HISTORIC PRESERVATION BOARD

June 29, 2017

Re: 44 Oak Street – Rooftop pergola and planters
CBL: 039 B011

6.21.17
44 OAK STREET
ROOF SCOPE PLAN
1/4" = 1'-0"

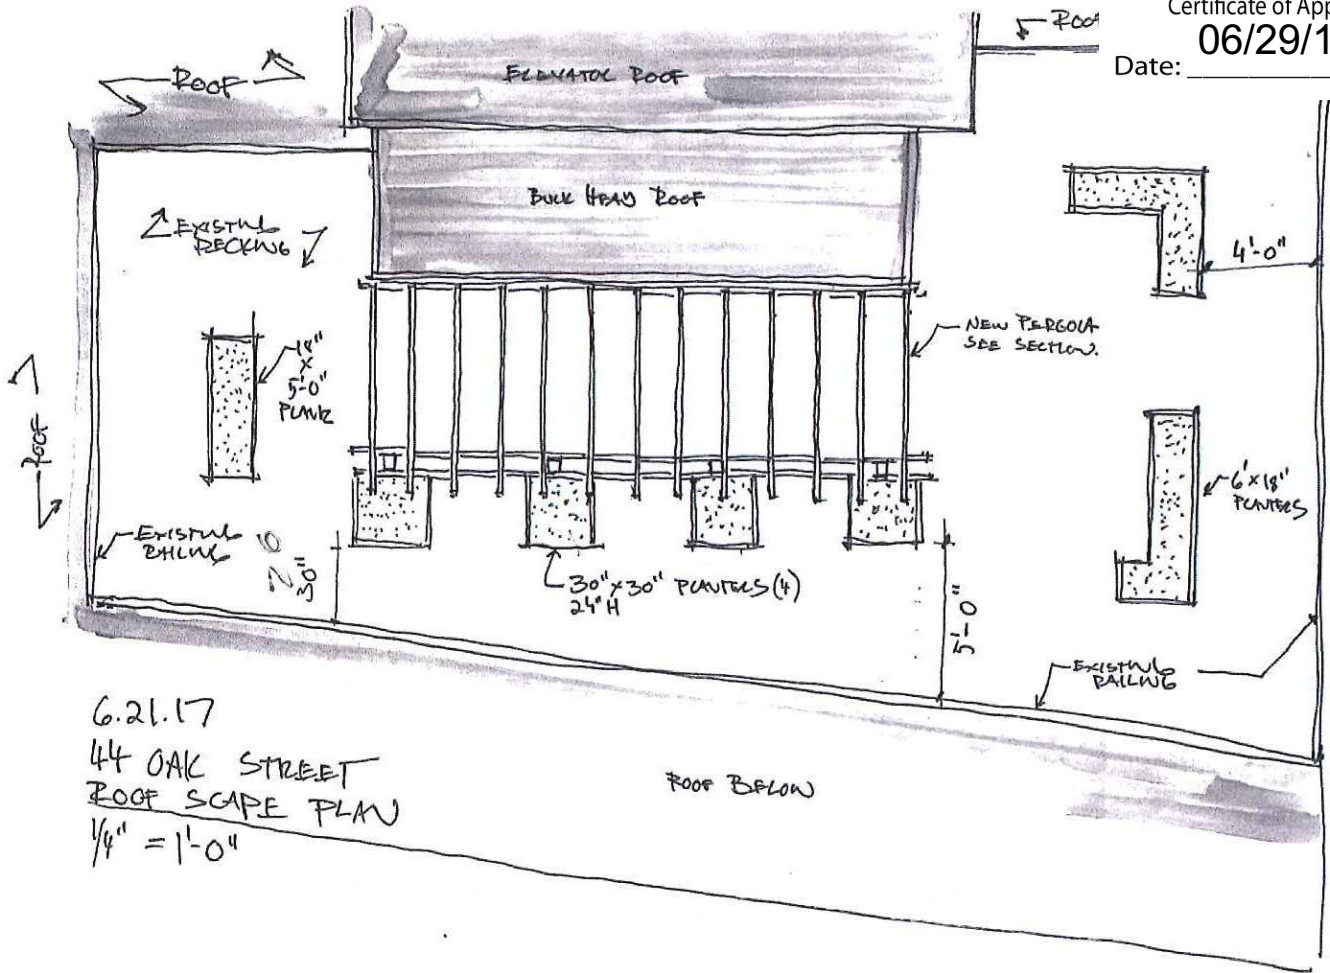
- Approved pergola design is the simplified and scaled back revision presented at the 6/21/17 Board hearing: 7' x 18', painted charcoal to match the stair bulkhead.
- The applicant is responsible for obtaining all required permits, including a building permit.
- Planters that are at least 4' from the railing shall be a maximum of 30" high. Planters located between 30" and 48" from the railing shall not be taller than 24" high. No planters are to be closer to the railing than 30".
- At no time shall the height of plants exceed 5' from the deck.
